From: Simmonds, Mark
Sent: 13 March 2019 12:07
To: _planningadvice
Subject: FW: H16-0154-19
Attachments: Mimecast Attachment Protection Instructions; Doorbell Plan 10.3.pdf; The Sessions House - Fireplaces 10.3.pdf

H16-0154-19

The Sessions House

Sheep Market

Example of existing doorway with external light

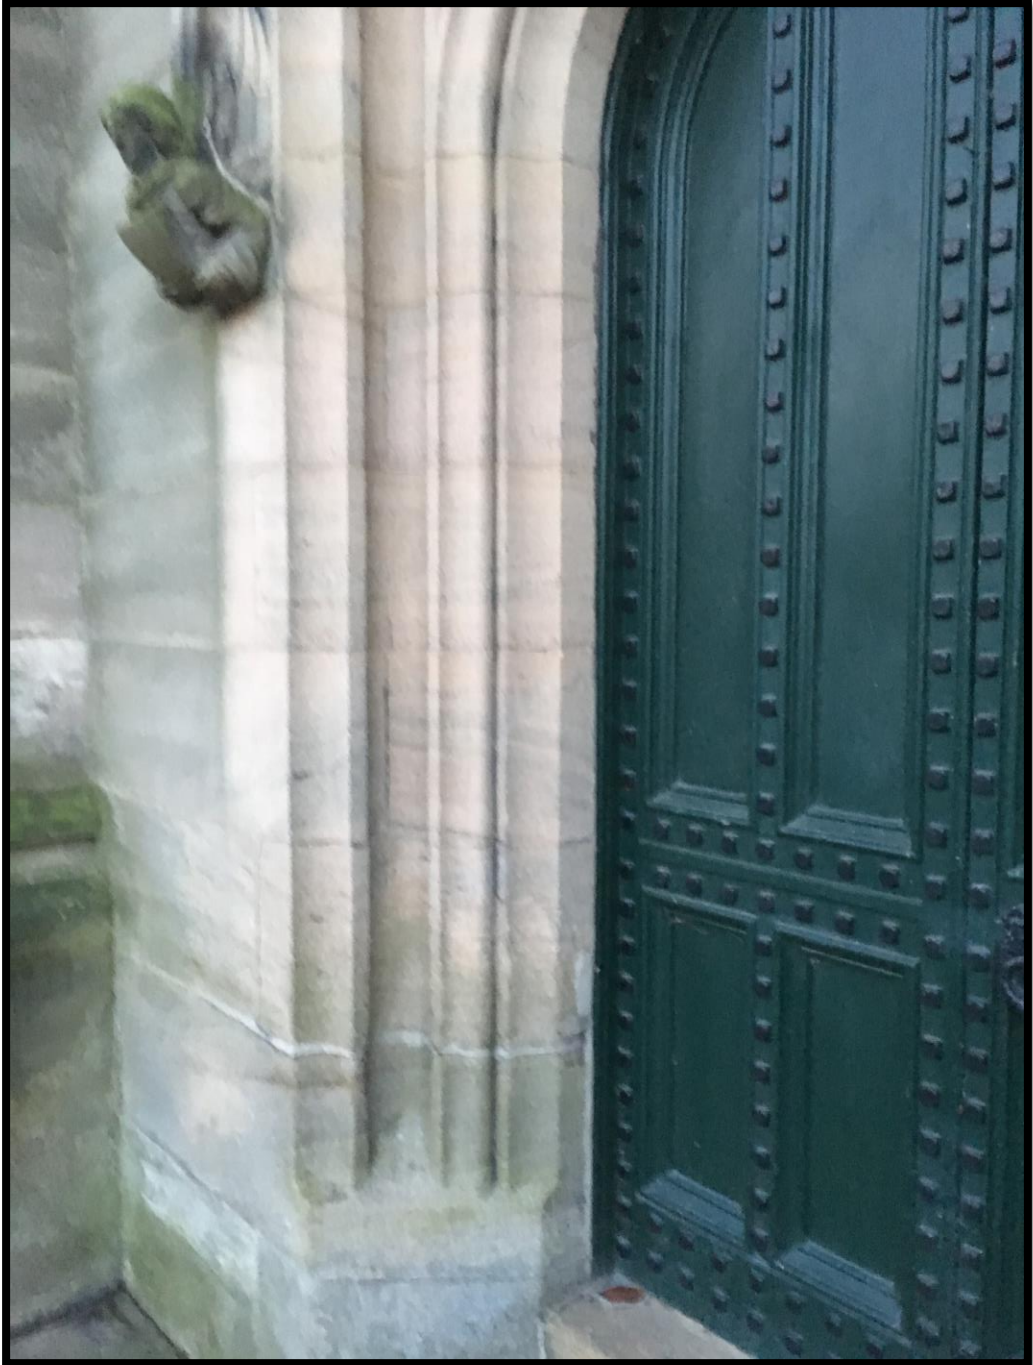
In general I am comfortable with the submission, however we do need a plan showing where the existing and new doorbell are/will go.

Please see attached plan showing the doorbell positioning we have planned.
